**Place Directorate
Regeneration and Culture
Planning and Building Control**

APPLICATION NO: 2020/0578

DESCRIPTION: Installation of a new 19 metre high monopole supporting 6 no. antennas with a wrap around equipment cabinet at the base of the column, 3 no. new equipment cabinets and ancillary development thereto (Application for Prior Approval)

LOCATION: Telecommunications Mast Tmuk And 3 77898, Greenwood Avenue, Worsbrough Dale, Barnsley, S70 4BH

Title:
265 PROPOSED SITE ELEVATION

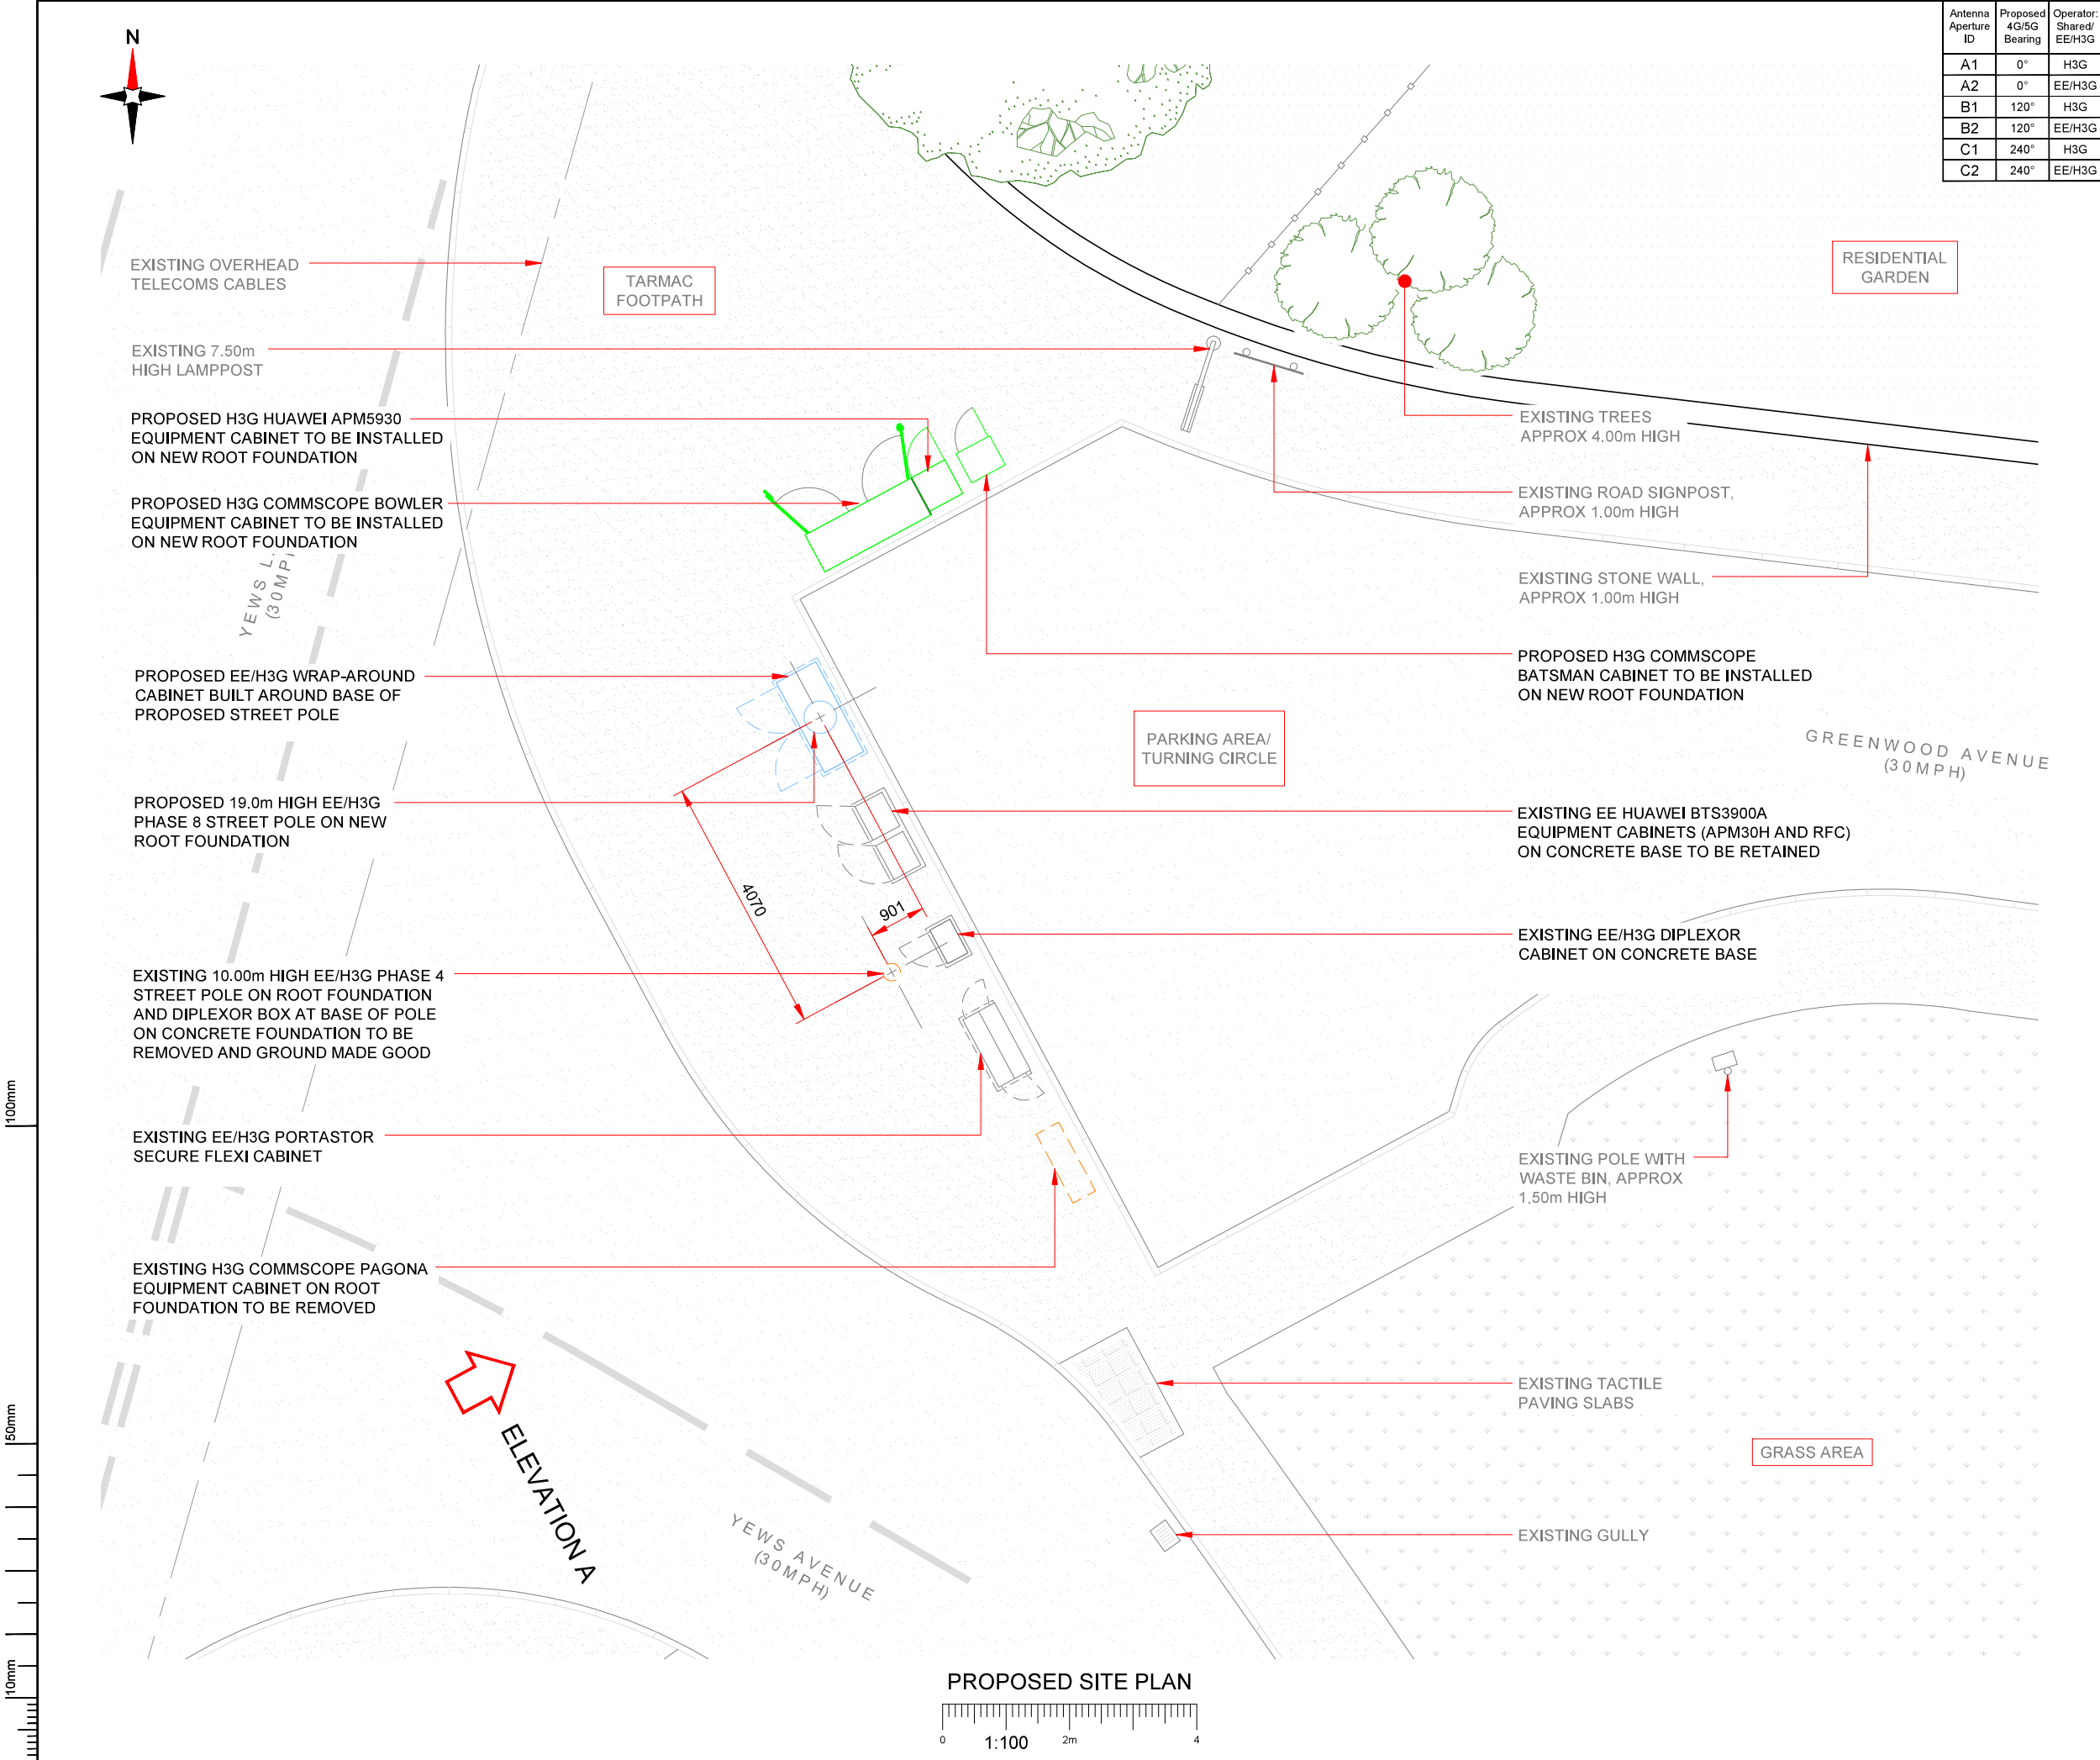
- 1 In the opinion of the Local Planning Authority the development would materially harm the visual amenities of the locality by virtue of its excessive height and the bulk of the antenna head which would make it an overly dominant feature on a prominent corner location that would be wholly out of scale with its surroundings. The proposal is therefore contrary to Local Plan policies D1 High Quality Design and Place Making and GD1 'General Development'. Furthermore, insufficient information has been submitted detailing alternative siting and design options.
